West Burton WSIs comments

As it currently stands we cannot agree these WSIs. Our position remains that the site has not been adequately evaluated in line with professional guidance and standard archaeological practice and as such we cannot recommend either of the proposed post consent strategies.

Figure 4. Archaeological mitigation areas within West Burton 3

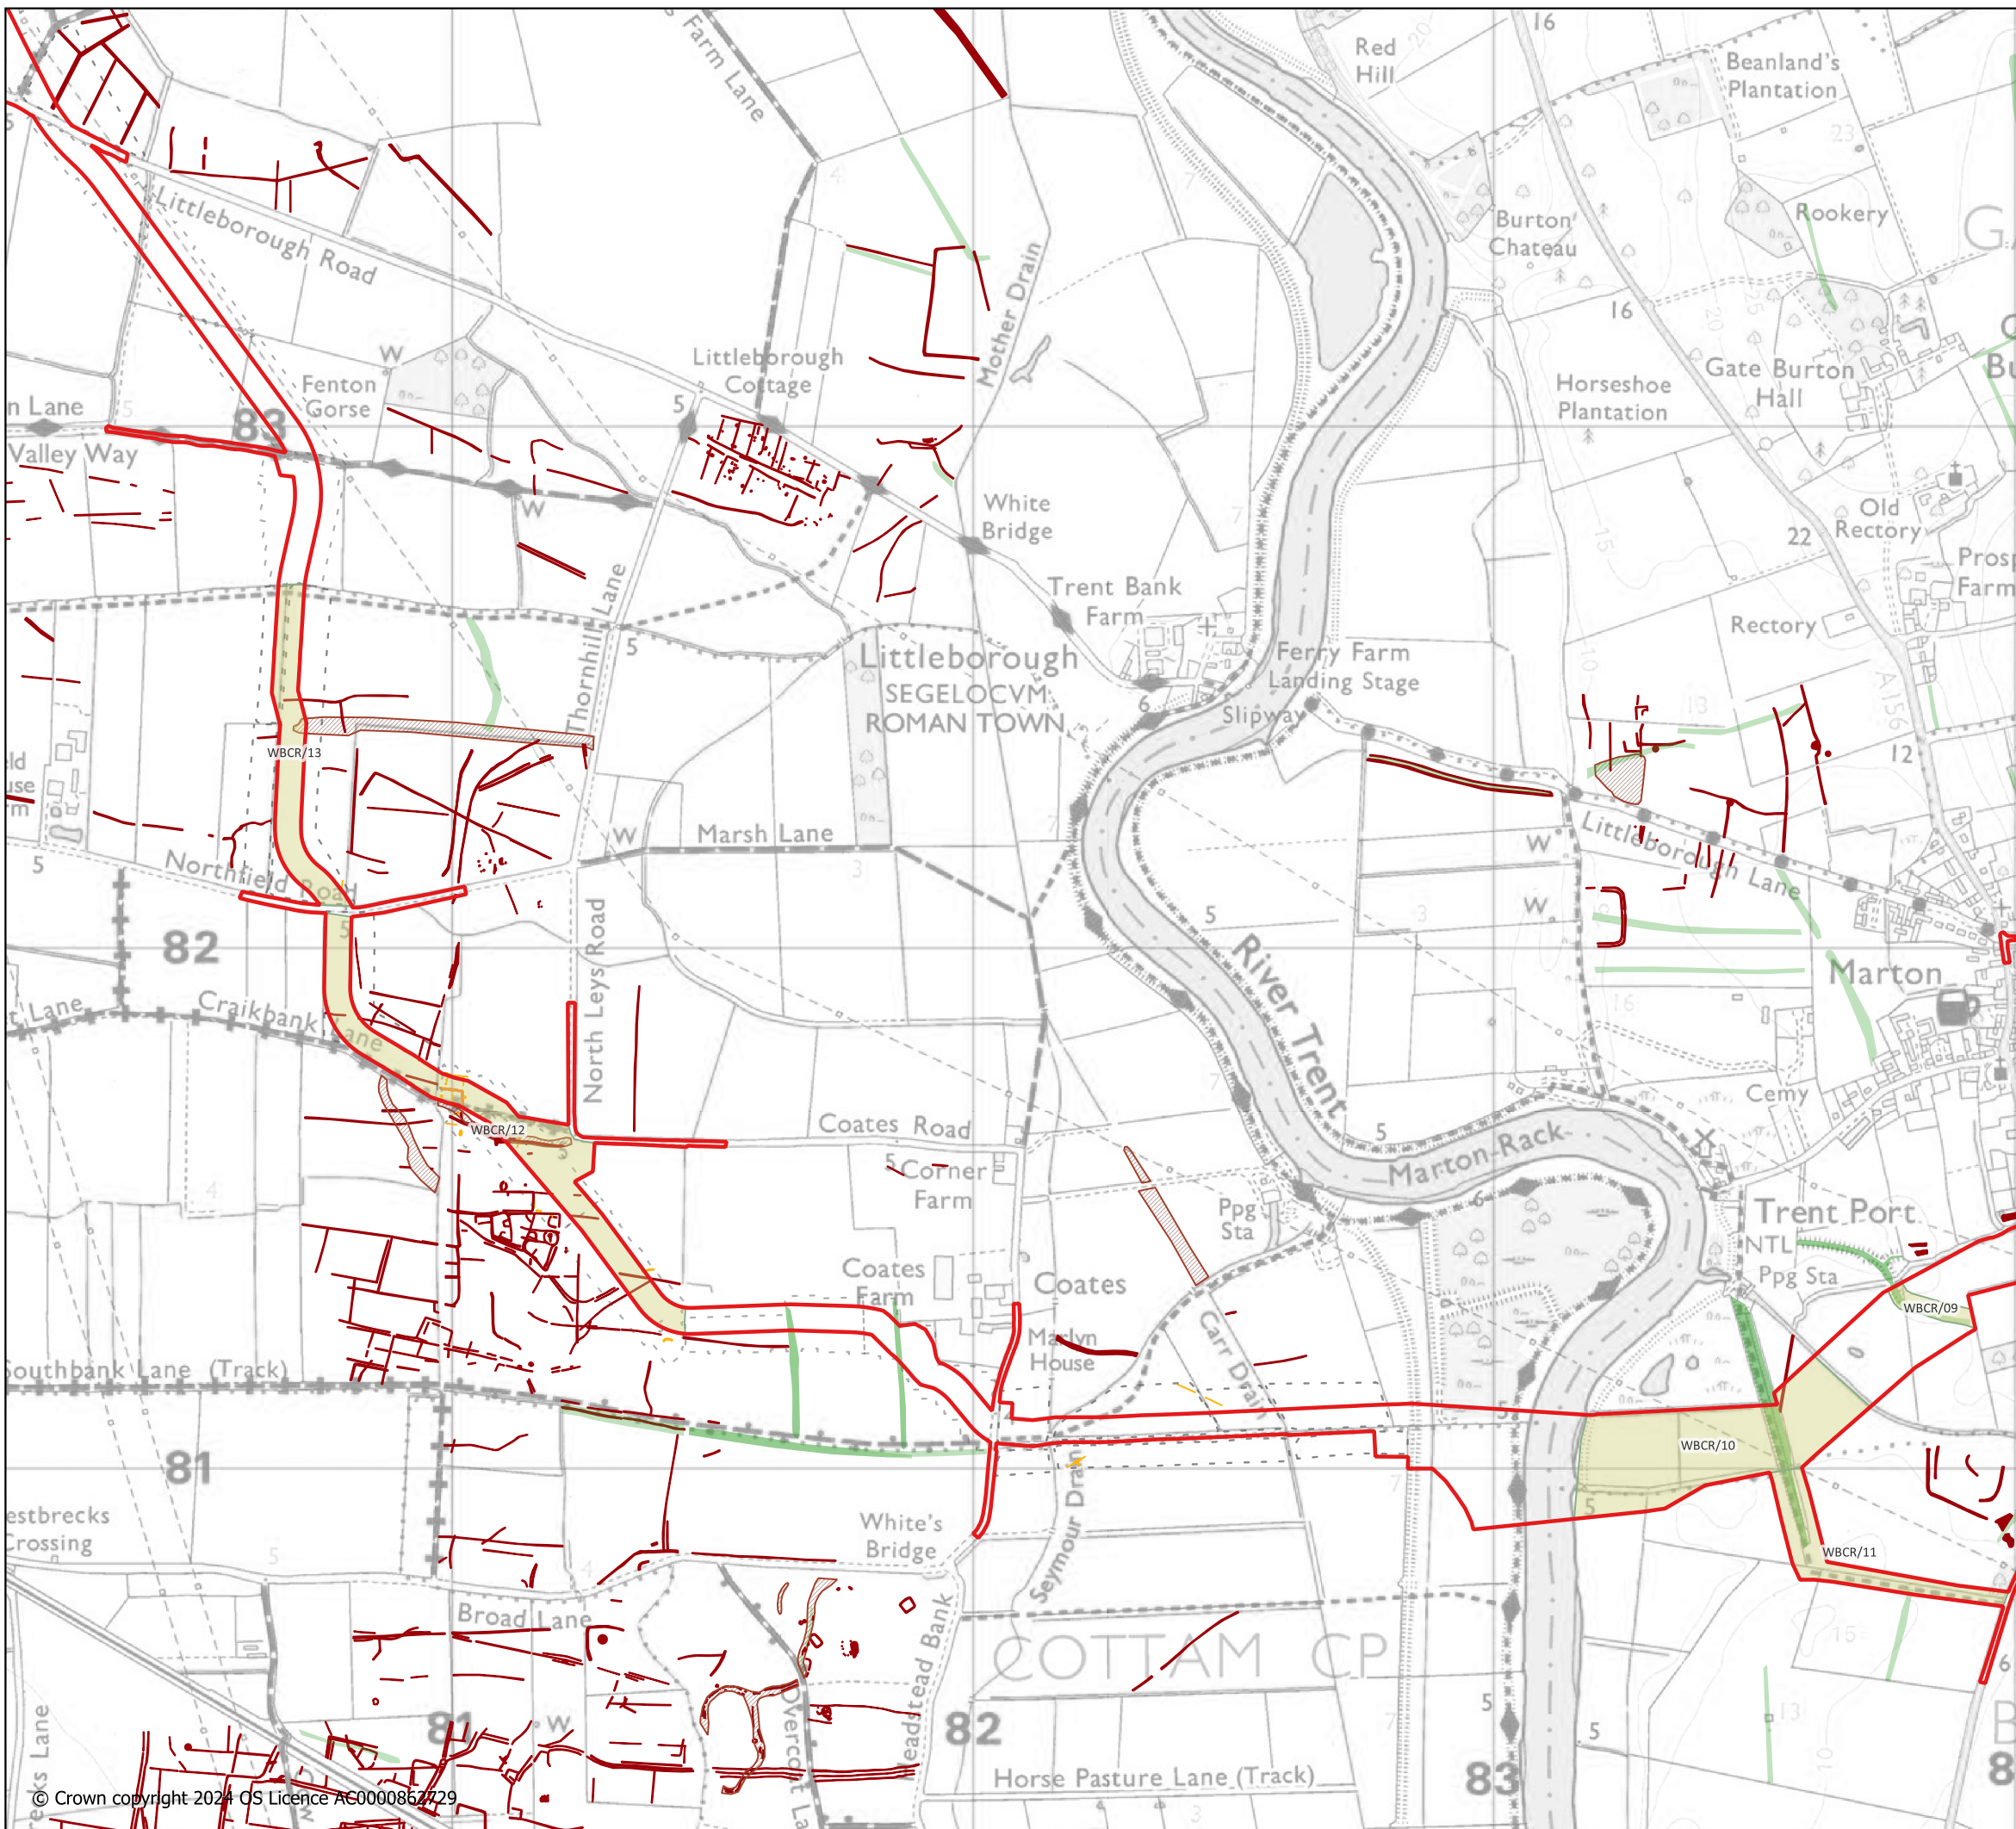
Regarding the figures, we have grave doubts regarding interpretation of the air photo and LIDAR features, for example Figure 4 which identifies banks as Post Medieval. Without intrusive investigation it is impossible to know the dates of these features. Some of these features do not align with Post Medieval field boundaries and some look like they may be part of Medieval settlement.
